**From:** [Tim Smith](#)  
**To:** [Bruce Zhang](#)  
**Cc:** [Kirk Osborne](#); [Planning and Safeguarding](#)  
**Subject:** [SEC=OFFICIAL] RE: Aspect Industrial Estate Referral SSD10448  
**Date:** Tuesday, 15 December 2020 17:12:11

Thank you for your email seeking feedback in regards to the proposed Industrial Estate at 804 Mamre Road (SSD-10448). WSA note the proposal is for the development of a series of warehouse format developments approximately 5km away from the airport. The site forms part of the Mamre Road Precinct, located in the Western Sydney Employment Area, and has been proposed in accordance with *State Environmental Planning Policy (Western Sydney Employment Area) 2009*.

Drawing Name:
Landscape Plan
Stage 1 Masterplan

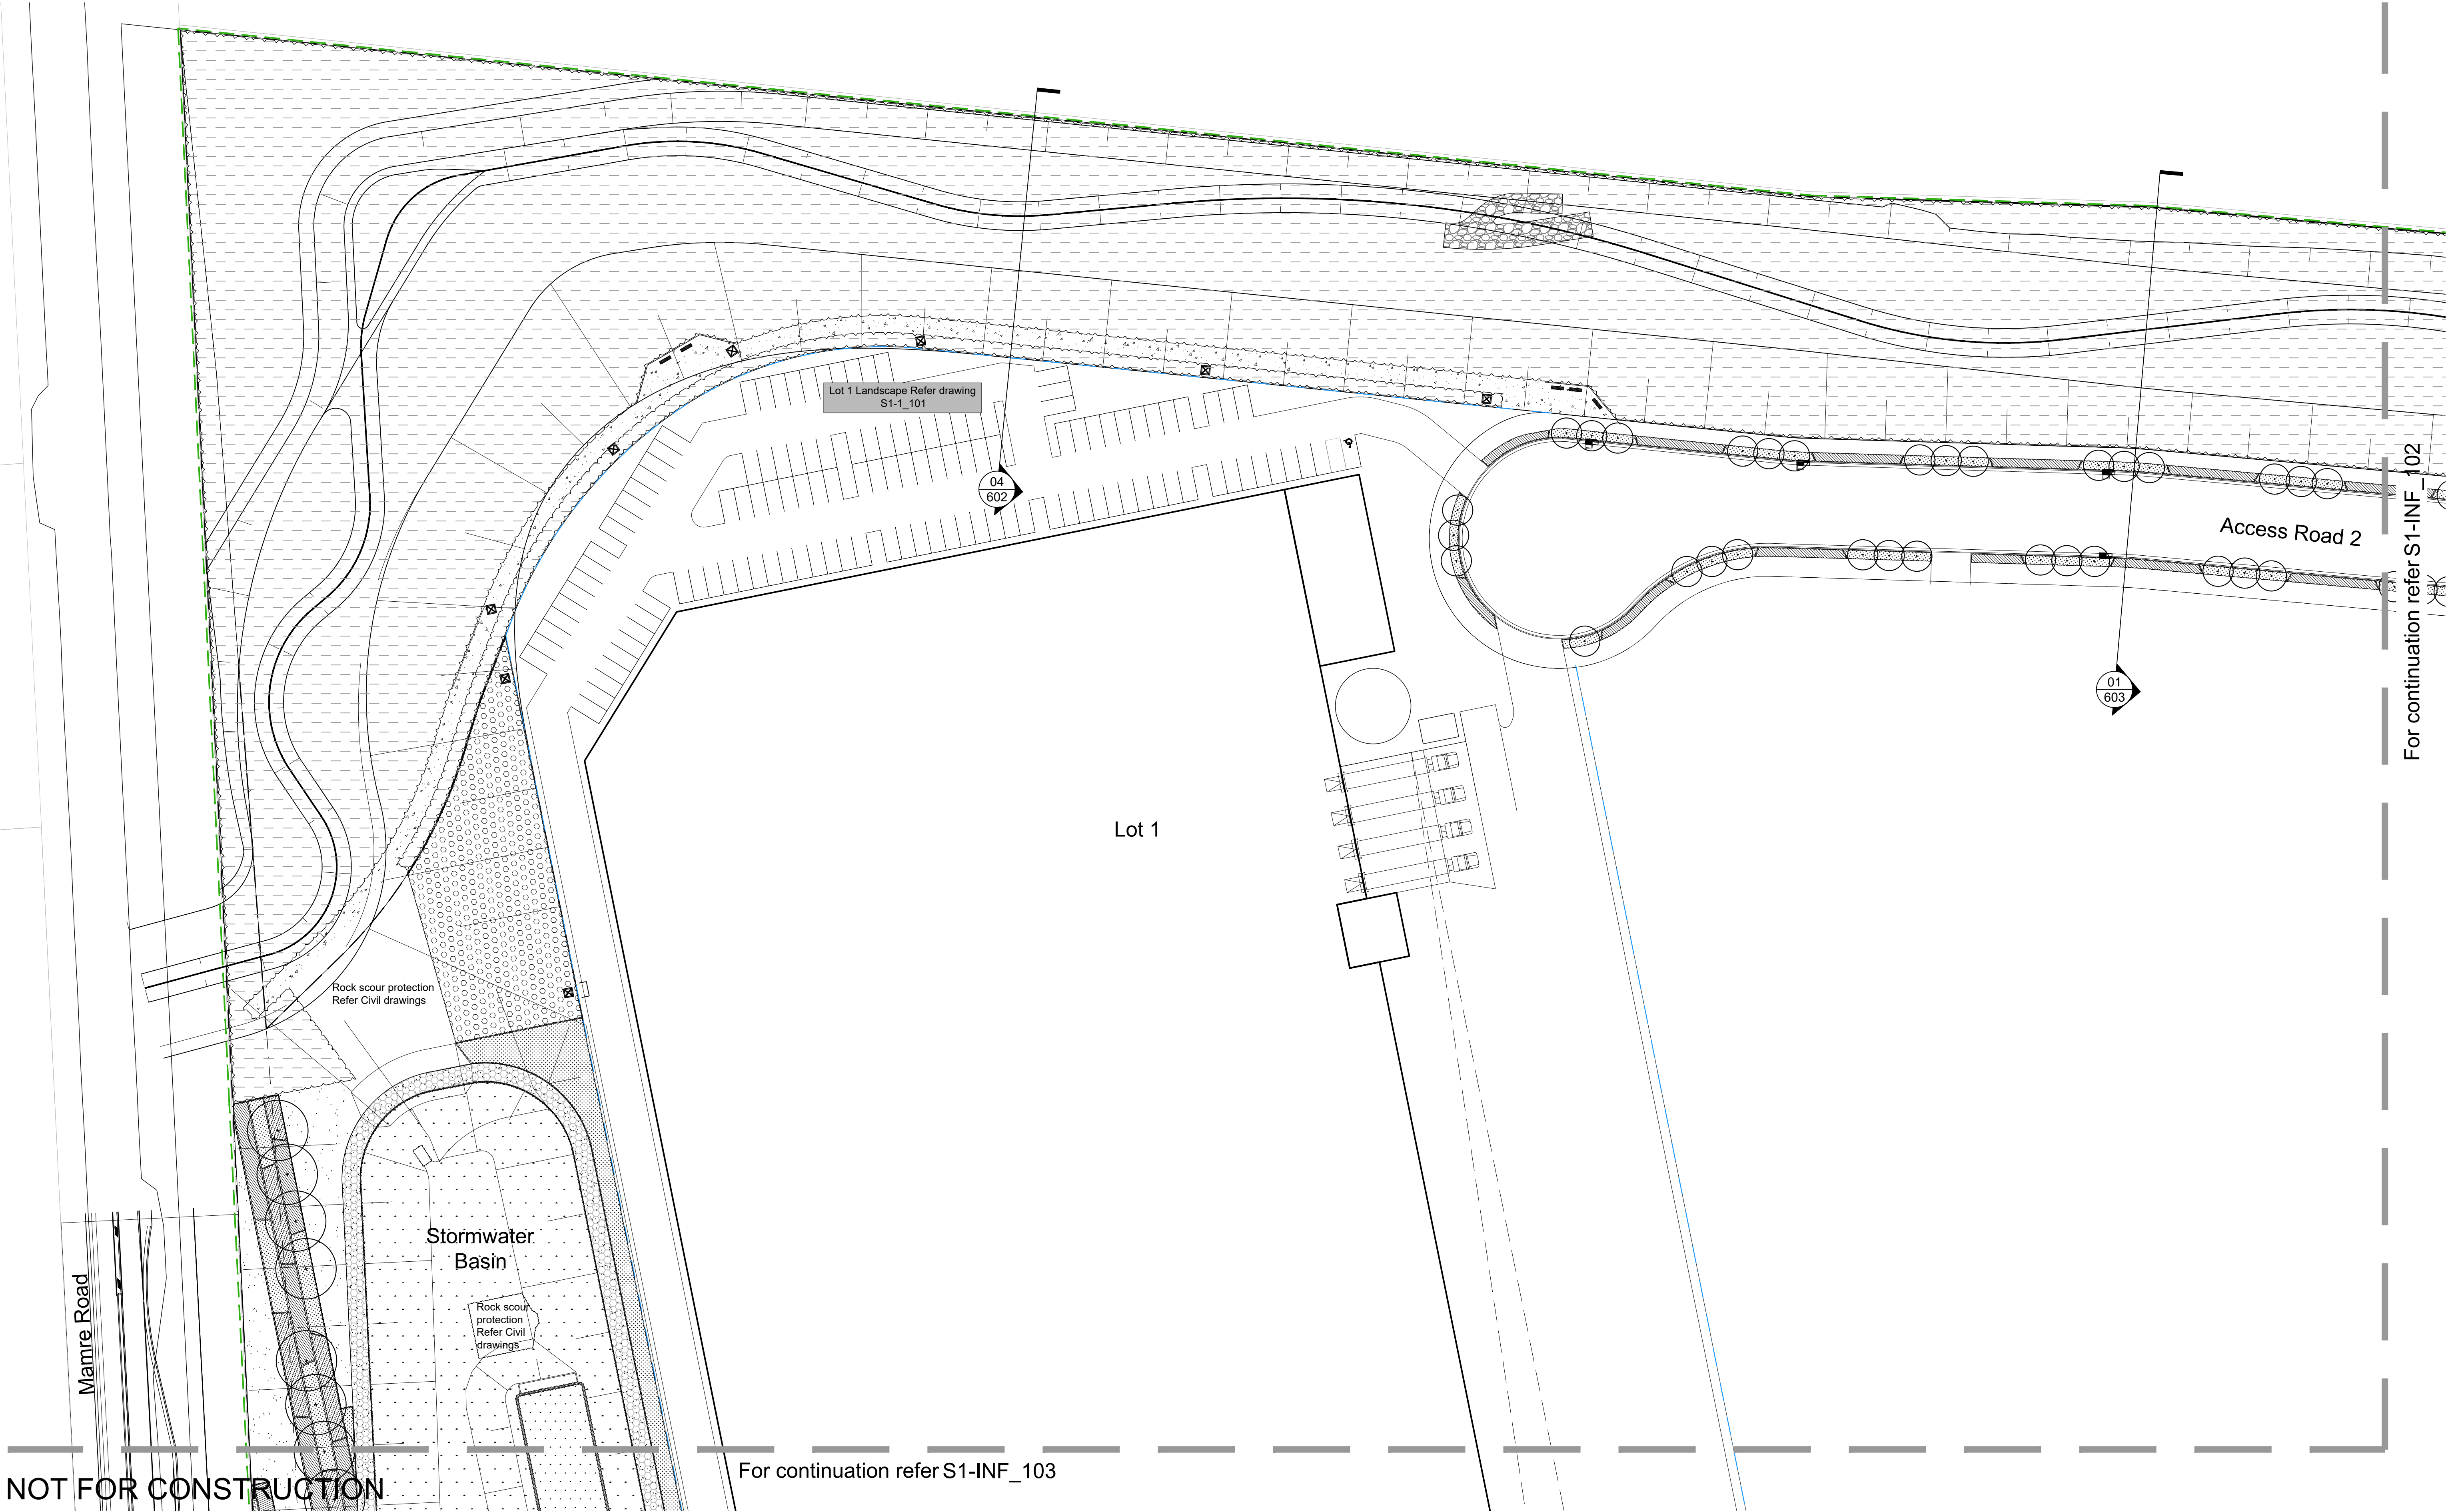
- **Wildlife Hazards – Vegetated Areas:** The proposal includes the realignment of an environmental corridor along the northern boundary of the site, and the provision of a riparian zone, including planting along the realigned corridor. The proposal also includes the provision of a stormwater basin on site. It should be ensured that this wildlife zone does not present an increased risk of wildlife attraction in relation to the future airport. The Aeronautical Impact Assessment that forms part of the DA package does not address the risk posed by these factors. Landscaping species should be selected to deter the attraction of birds / flying foxes.
